Marge Schmuckal - RE: 850 Baxter Blvd - 2014-2356 - 166-A-010

From: Marge Schmuckal <MES@portlandmaine.gov>
Date: October 14, 2014 at 10:30:25 AM EDT
To: <sclark@ledgewoodconstruction.com>
Subject: 850 Baxter Blvd - 2014-2356 - 166-A-010

I am reviewing your submission of Seaside. I am seeing a new roofing plan and I am not sure where that is in the building or on the site. A site plan has not been submitted with your application. Can you submit a site plan showing where such work is happening? Your permit will be on hold until such time I can finish my zoning analysis

Drawing Name: SITE PLAN	
Scale: AS NOTED	SHEET: L1.0
Date: JULY 18, 2014

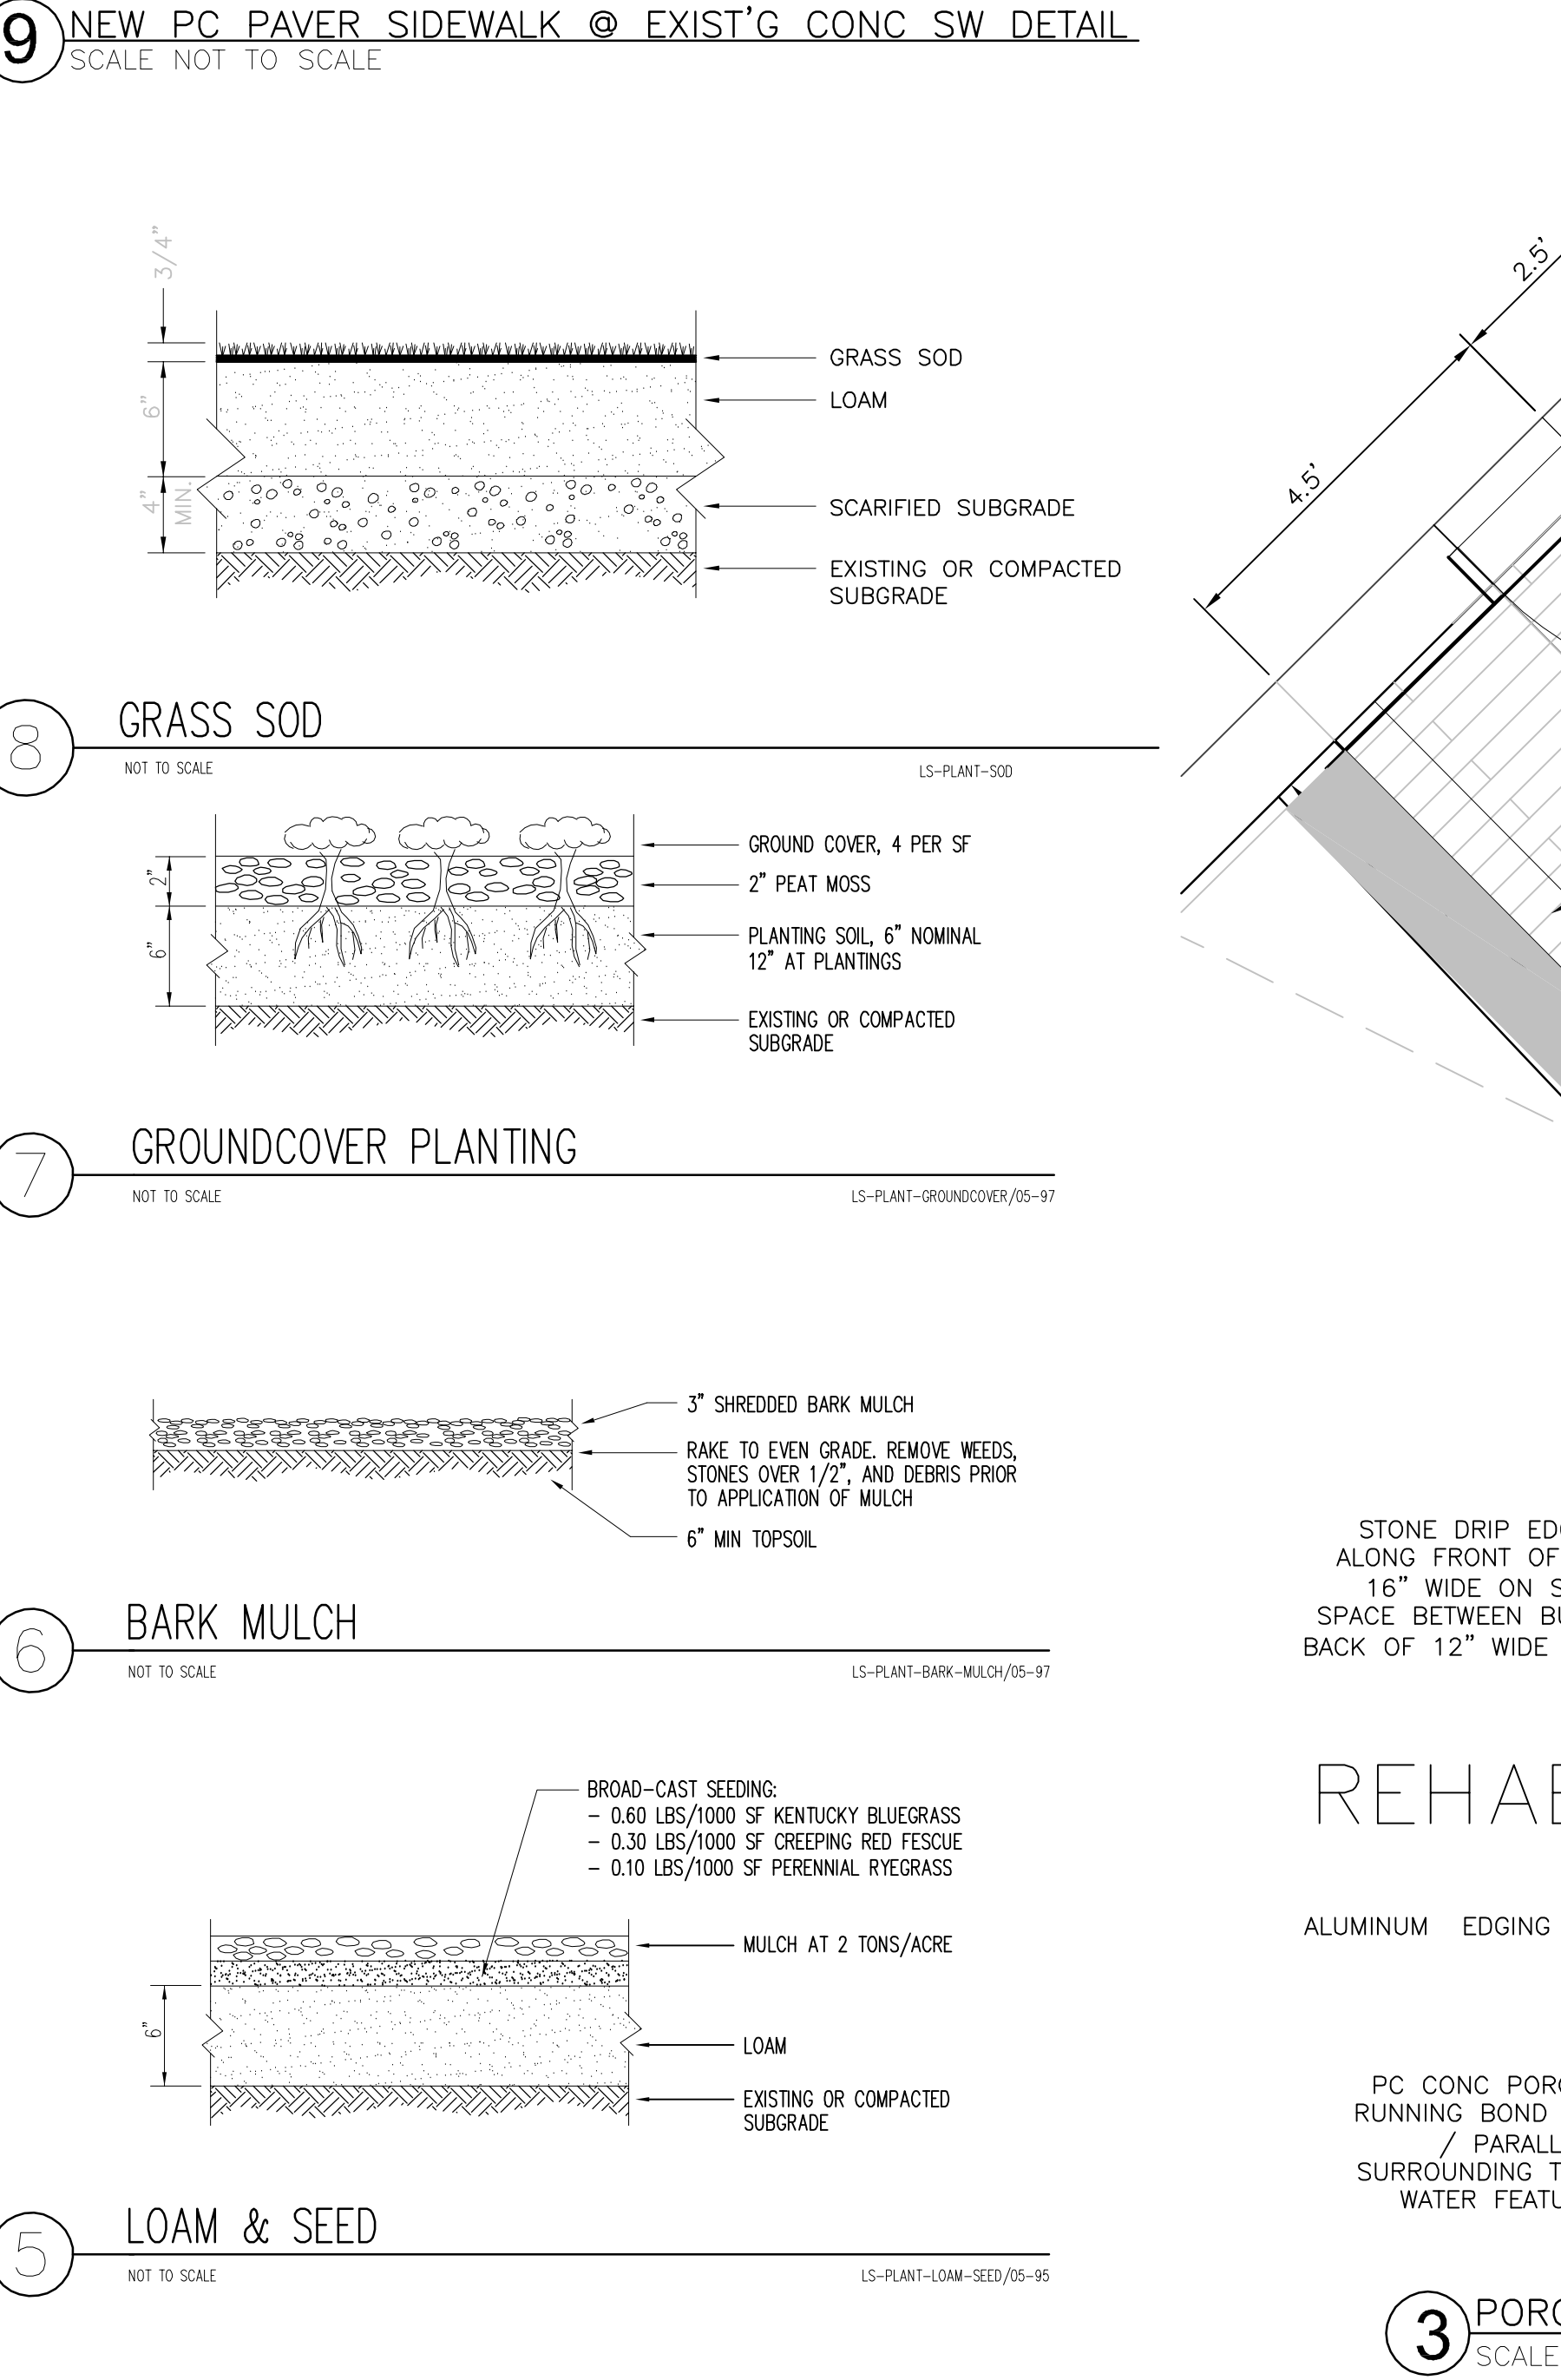
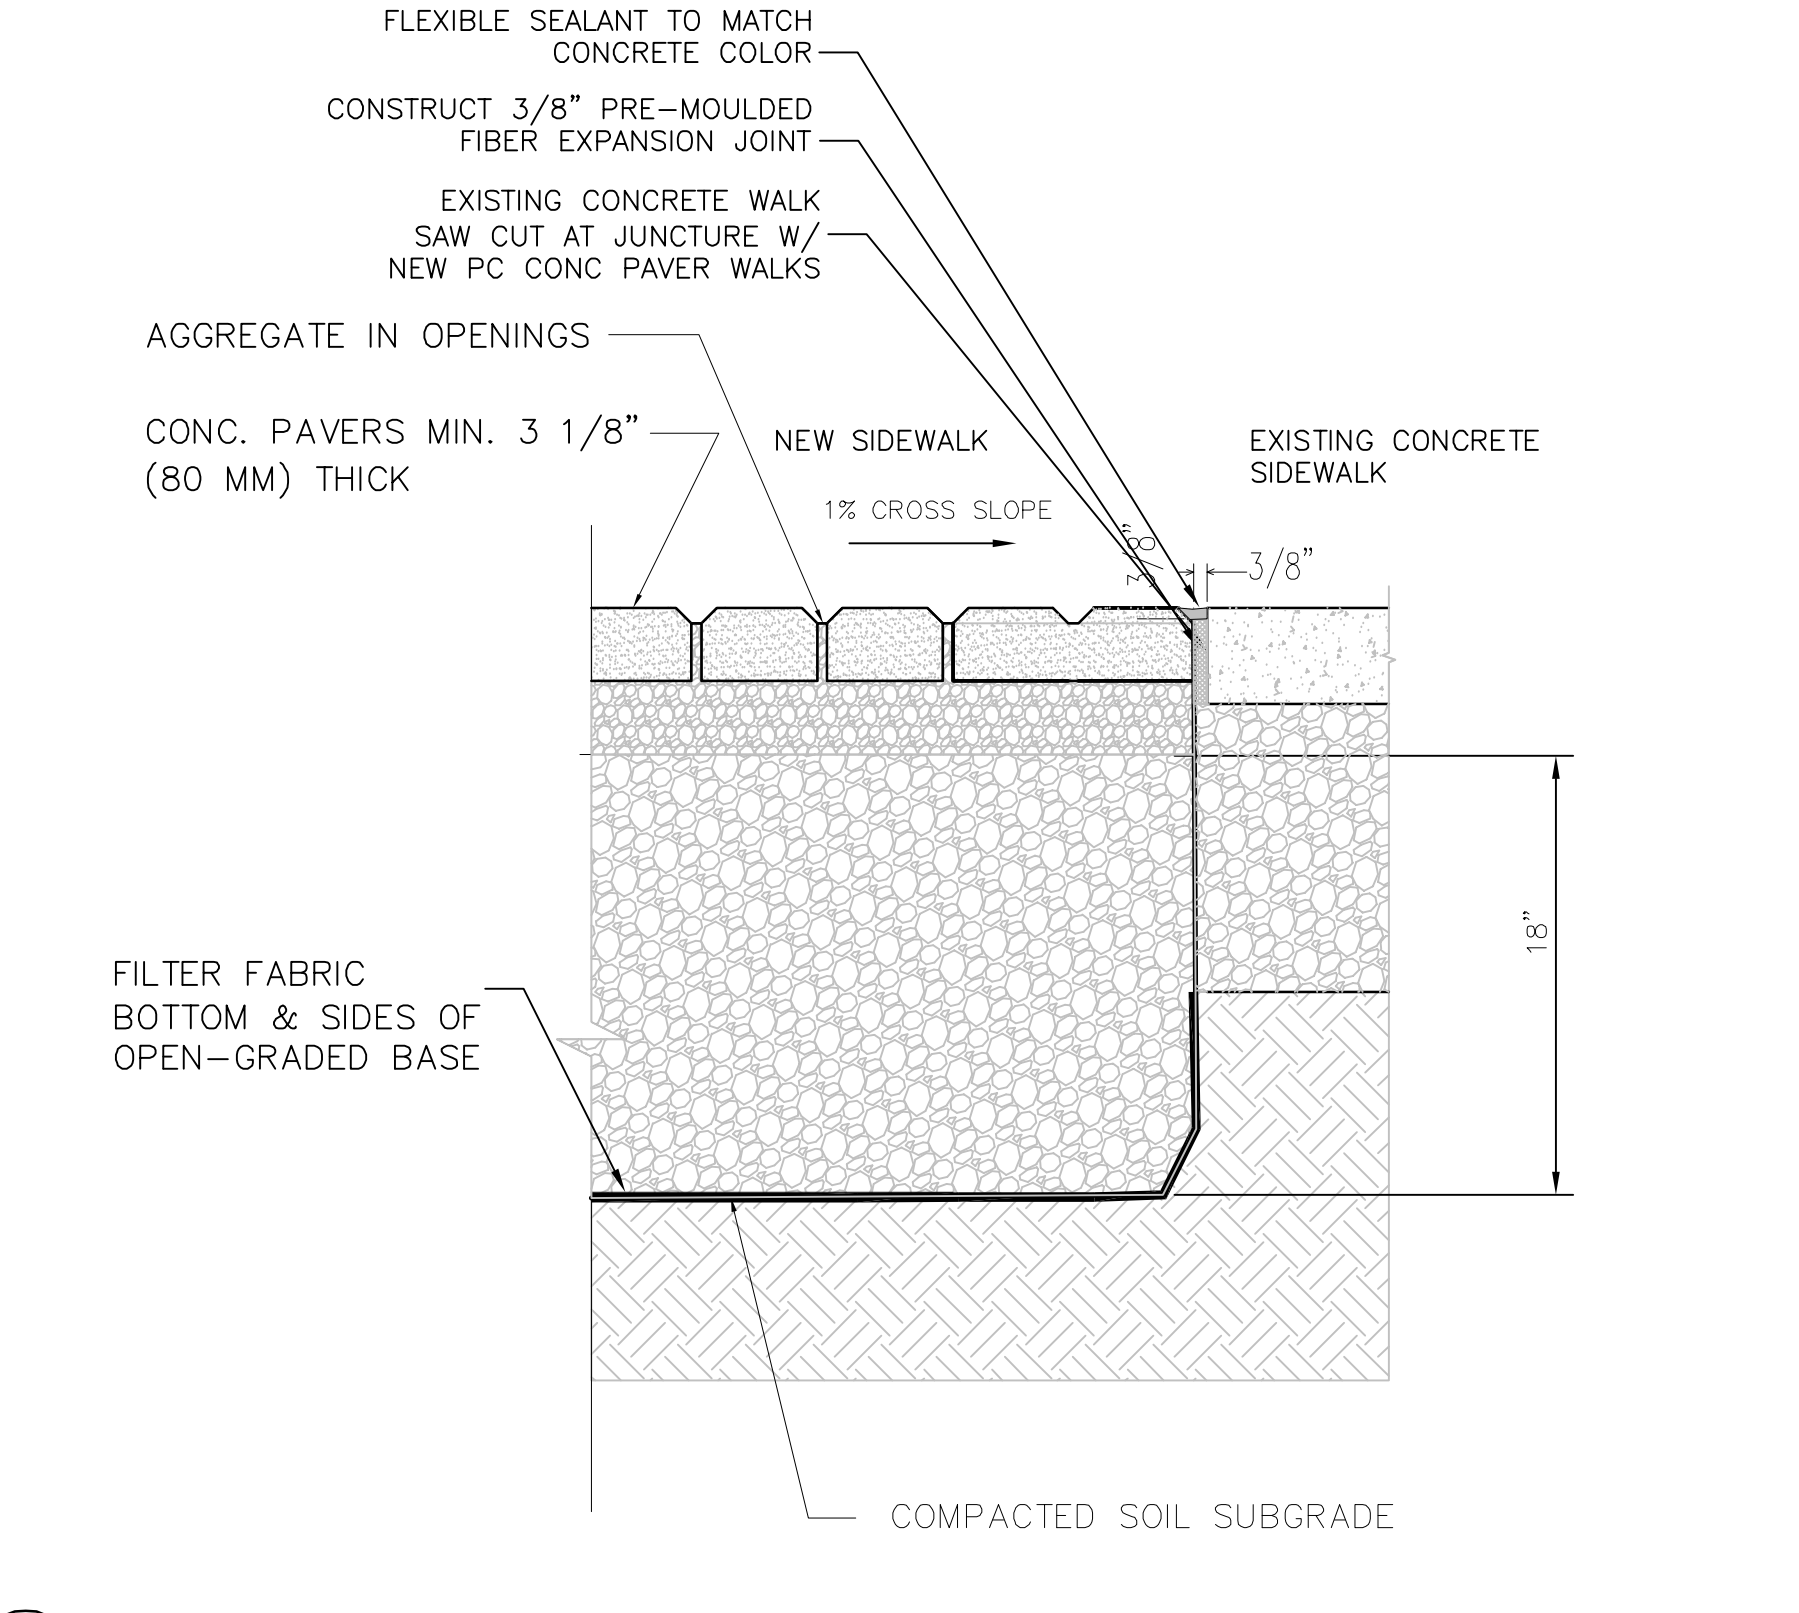
This should be shown on a site plan as to where it is located. Is all the other work interior?
Marge

We are going to need a site plan for the roof location.

See the attached site context drawing for your review.

There is a structural concrete slab at the face of the building with a low pitch roof creating an open porch. We are removing this roof, constructing walls and a new pitched roof. We are not adding to the existing footprint. Does this help or do you need additional information
